March 5, 2024

Mr. Curtis Cherne, PE
Senior Engineer, Planning Department
Development Review Services
City of Albuquerque, New Mexico

RE: R+L Carriers Maintenance, 2350 Aztec Rd NE
Site Dimensional and Paving Plan

In response to your review email dated February 28, 2024, we offer the following responses, in ***bold and italics***, to the outstanding comments:

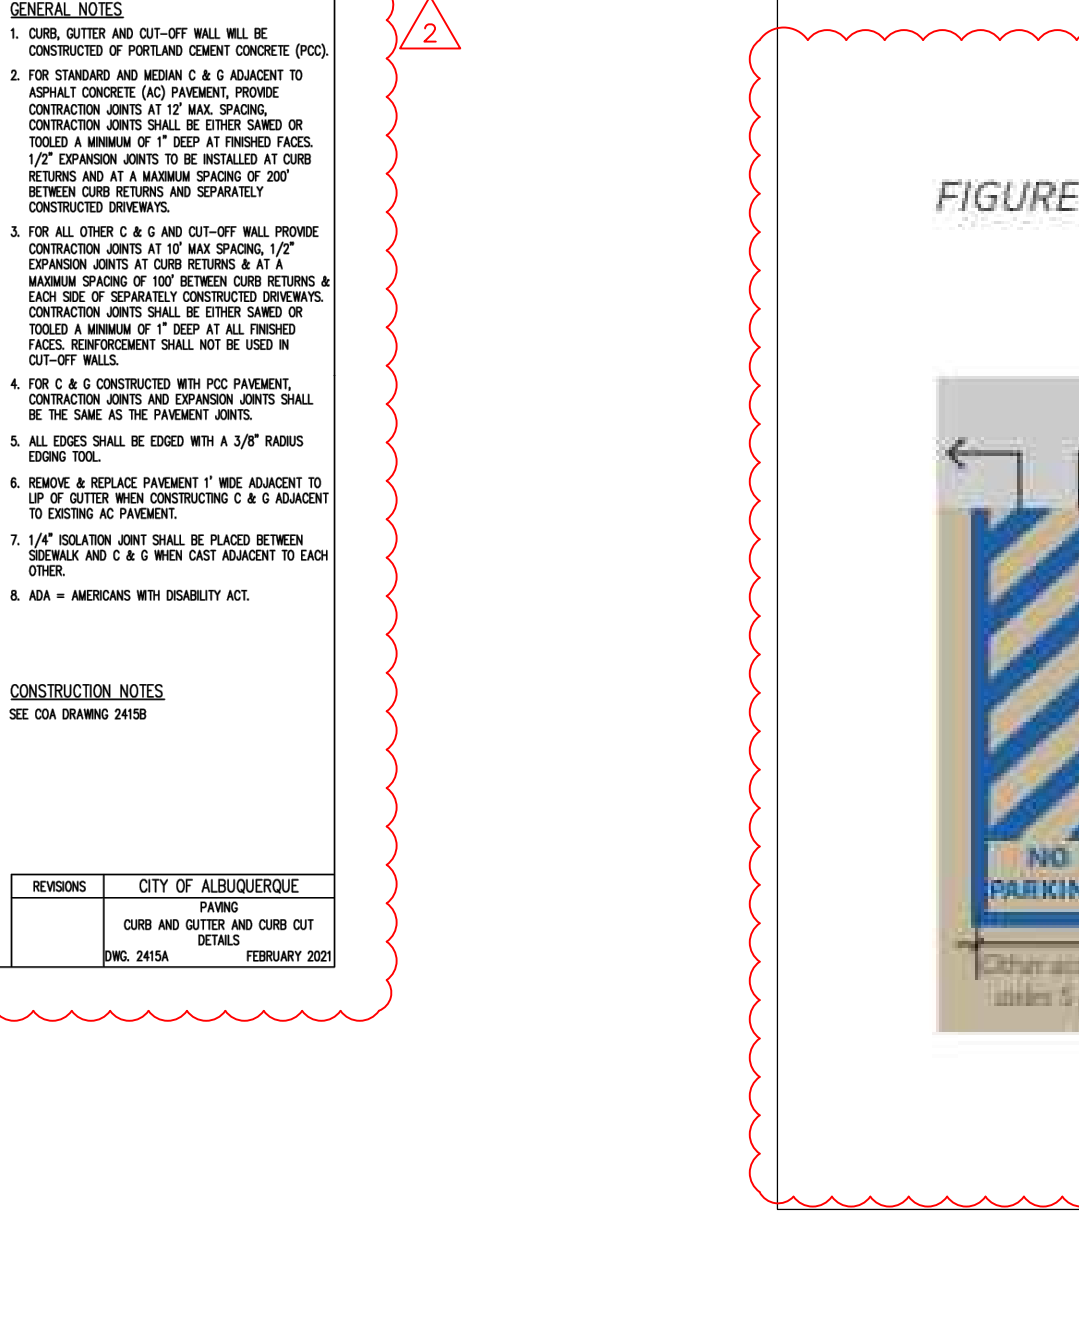
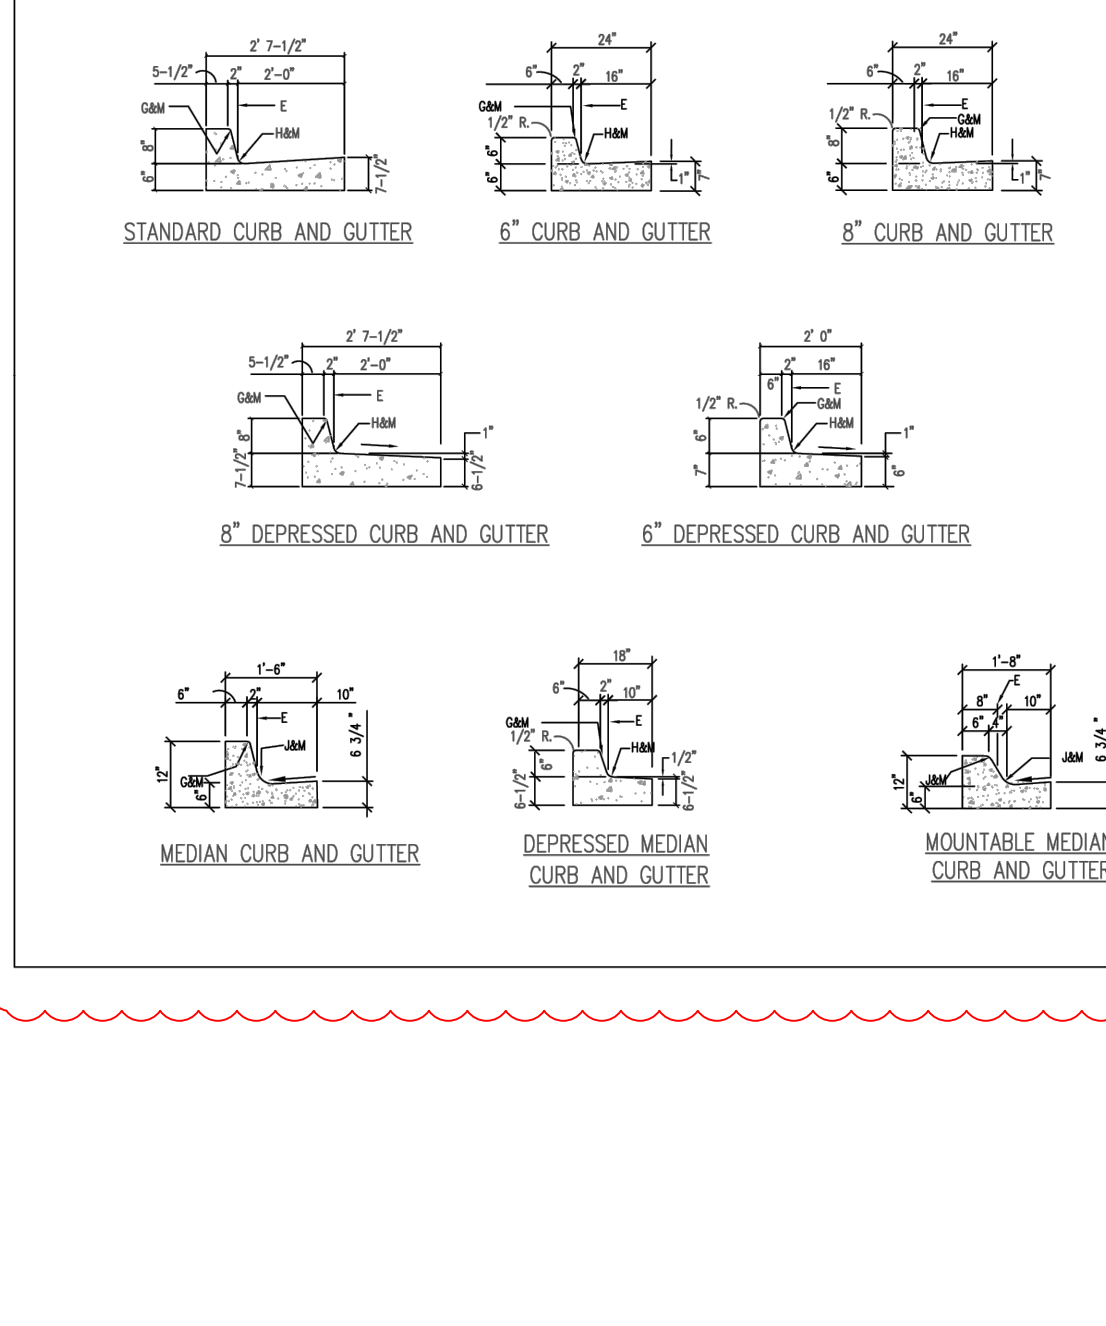
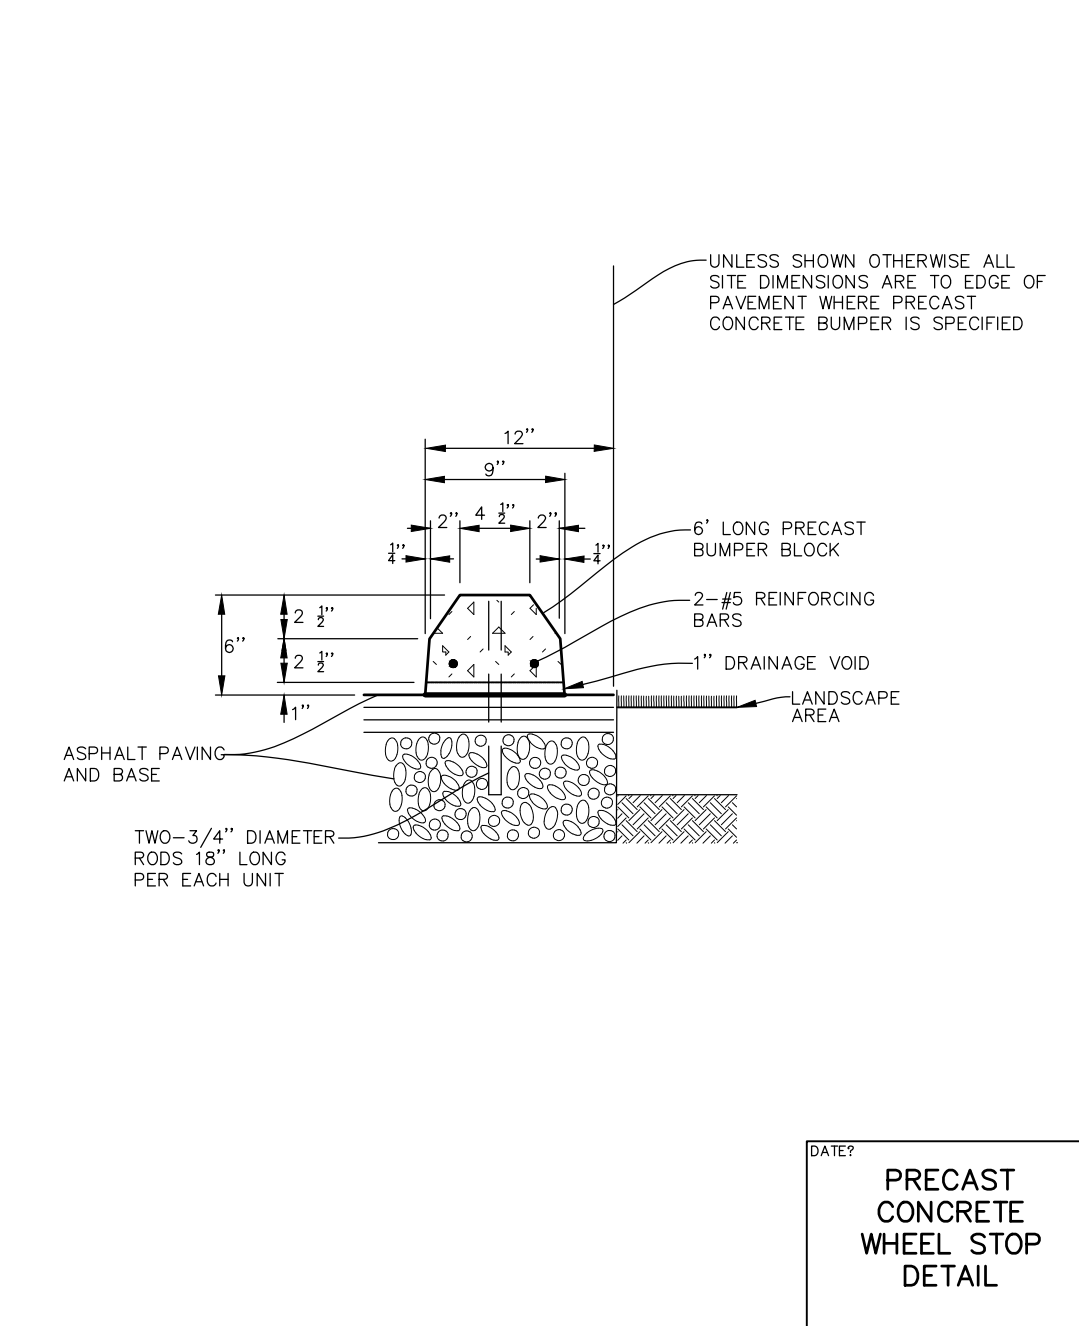
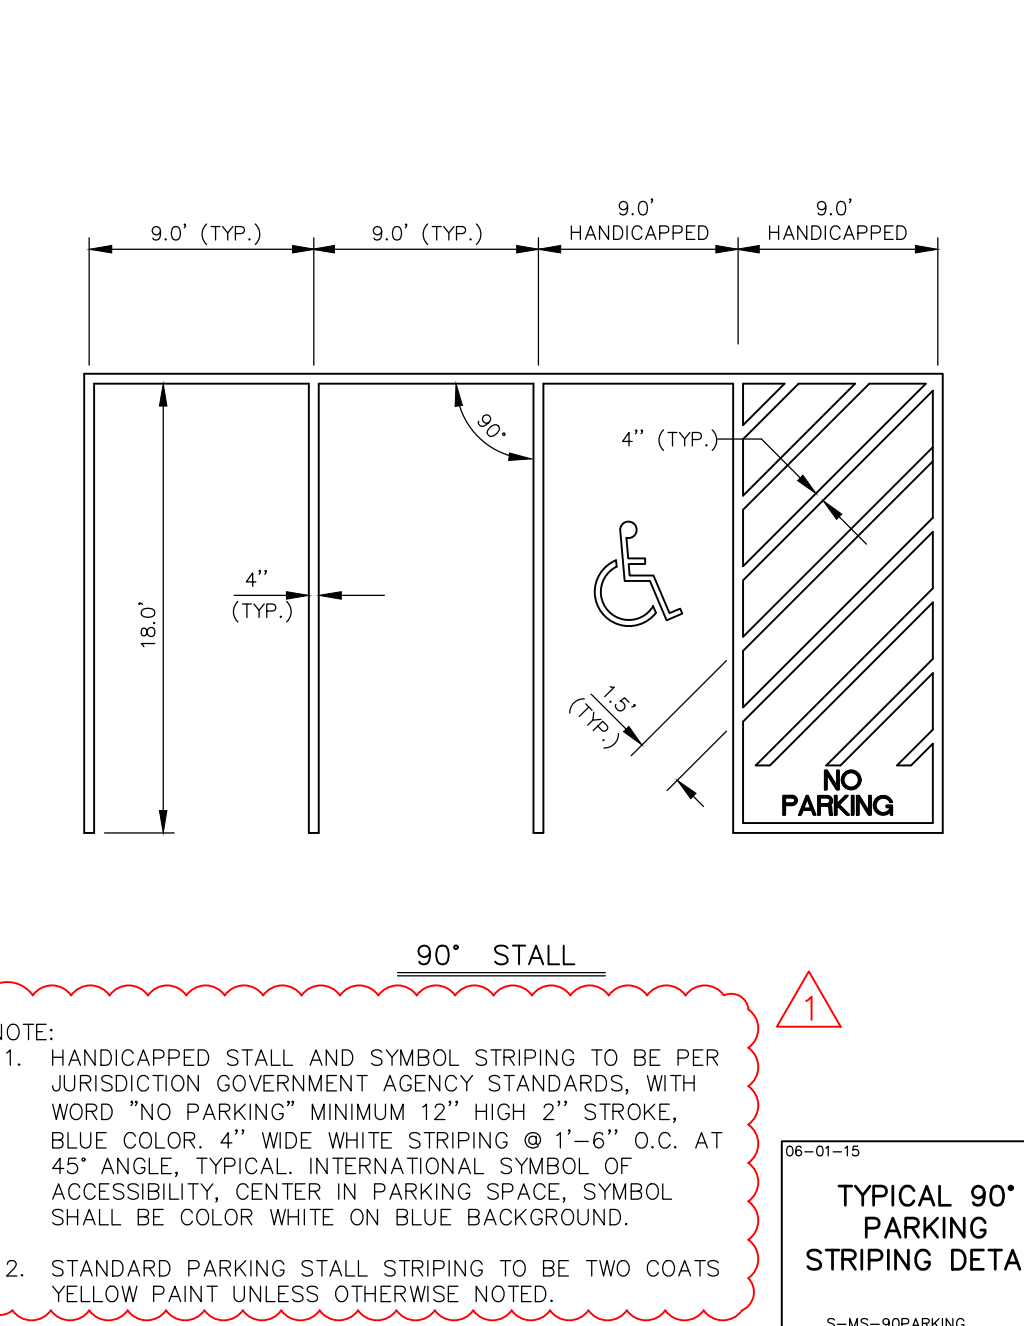
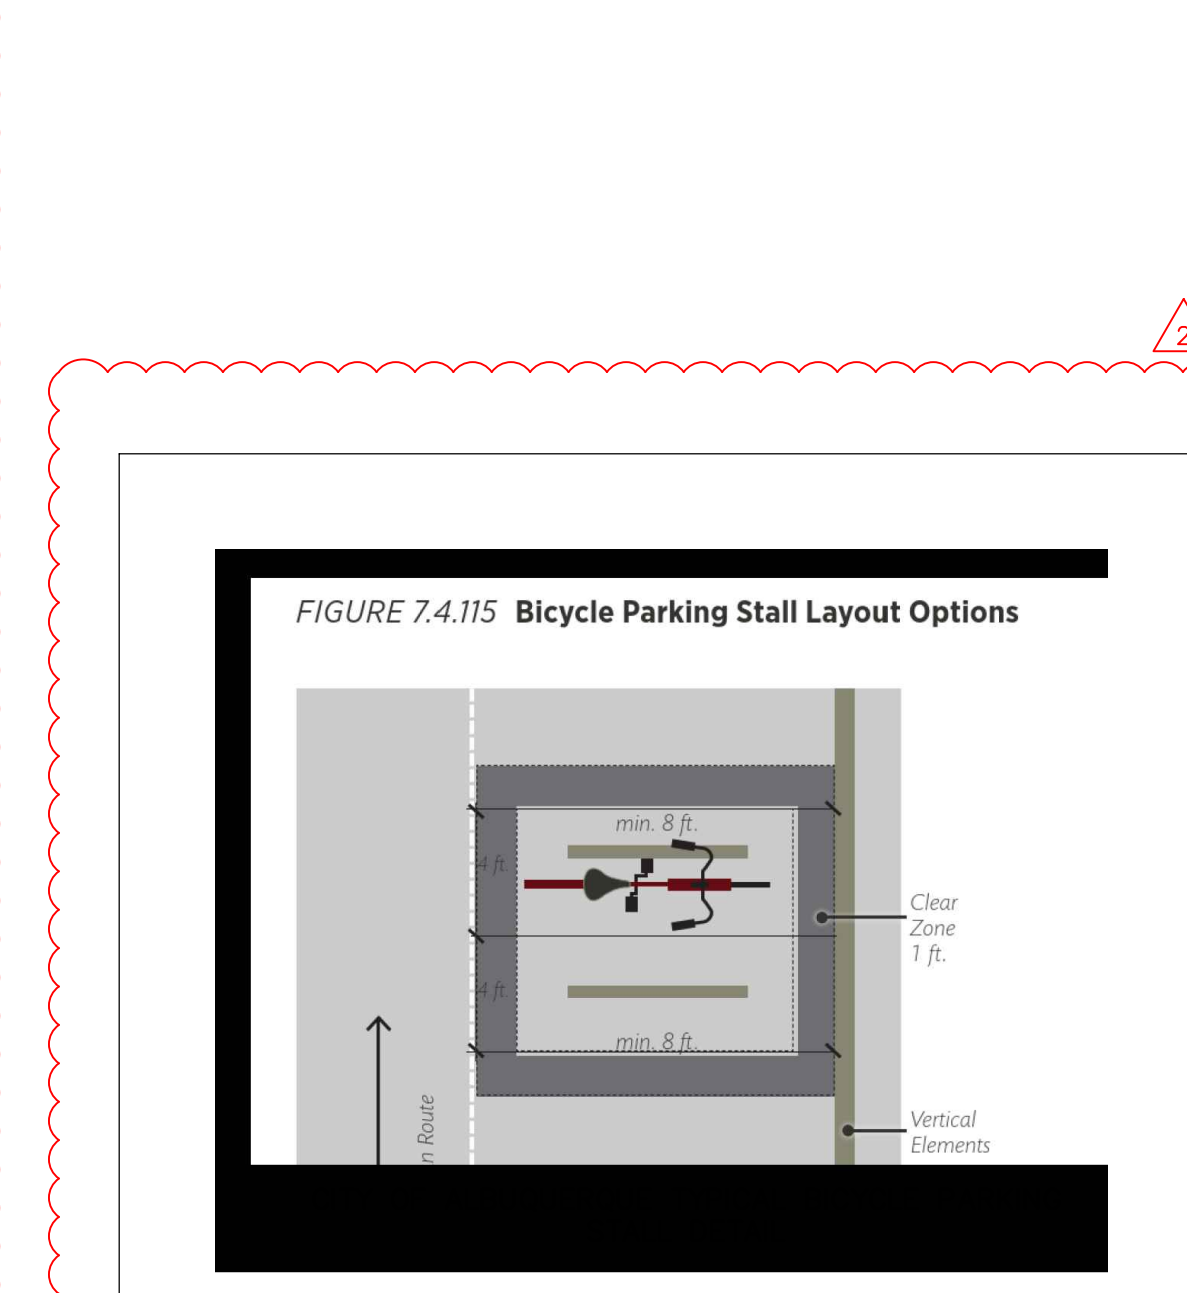
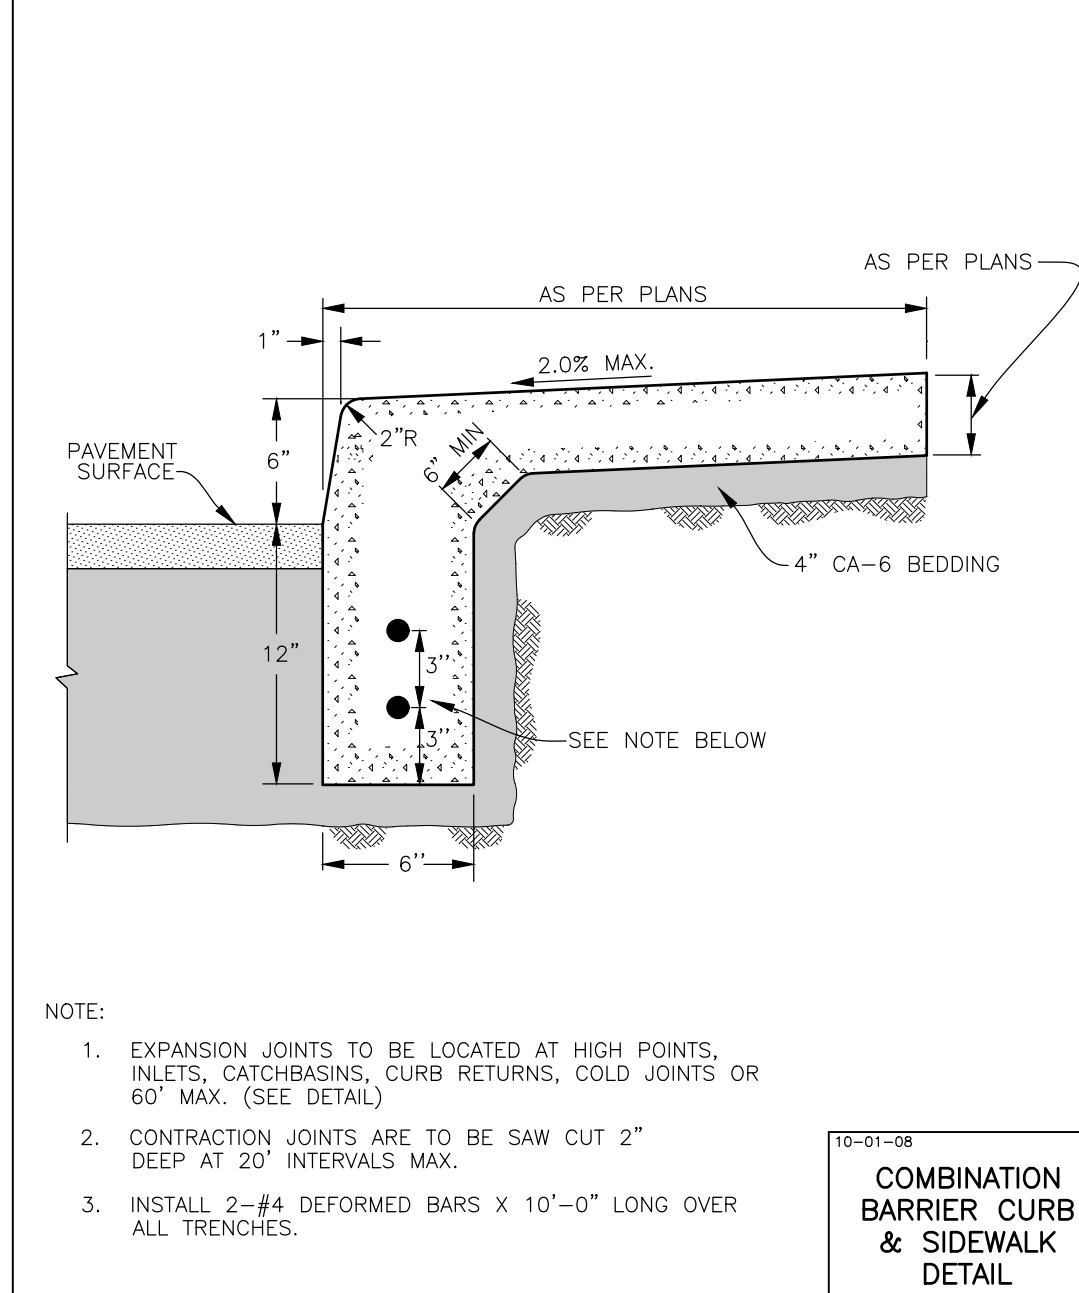
1. Is the sidewalk adjacent to the building a “Zero Height Combination...” or is it the “Barrier Curb...” as shown on Sht 11? This will affect the need for ramp(s) and/or parking bumpers. Provide a Paving/Keyed note.

2. On a 5’ wide sidewalk, there will only be room for a parallel style (sidewalk flush with parking surface then ramp up to sidewalk grade) ramp.
Response: The sidewalk and curb adjacent to the building is a zero height curb and the ramp is not needed.

3. The sign legend references MUTCD signs that do not have acceptable language in New Mexico (missing towed/fined) and does not have required height dimension. The detail on Sheet 11 does. It could be referenced. Please add a title to the detail.

Response: Notes referencing details on Sheet 11 have been added.
5. Include the mini clear sight triangle at the Employee Entrance and include the Sight Distance Note. See attached image.

Response: The mini clear sight triangle and note have been added at the Employee Entrance, please refer to the updated sheet 5.
6. Fence cannot interfere with the clear sight triangle. What type of fence is it? Fence can be

set back near the Employee entrance/exit so it is out of the mini clear sight triangle.

7. Contractors regularly install incorrect types of bike racks. The style shown in the image above meets our code. Bicycle parking regs are attached.

Response: A note calling out a “Zero Height Combination Curb and Gutter” curb type has been added. The wheel stops (parking bumpers) are shown at each parking space, and a noted on the Site Dimensional Plan.

Response: The proposed fence is a chain link fence with barbed wire, the fence detail has been added to sheet 10, please see attached. The mini clear sight triangle has been added to the Employee Entrance, and the proposed fence doesn't interfere with the clear sight triangle.

Response: The bicycle parking rack detail per the regulations has been added, please refer to the sheet 11. Bollards separating bicycle parking from the driveway have been added.
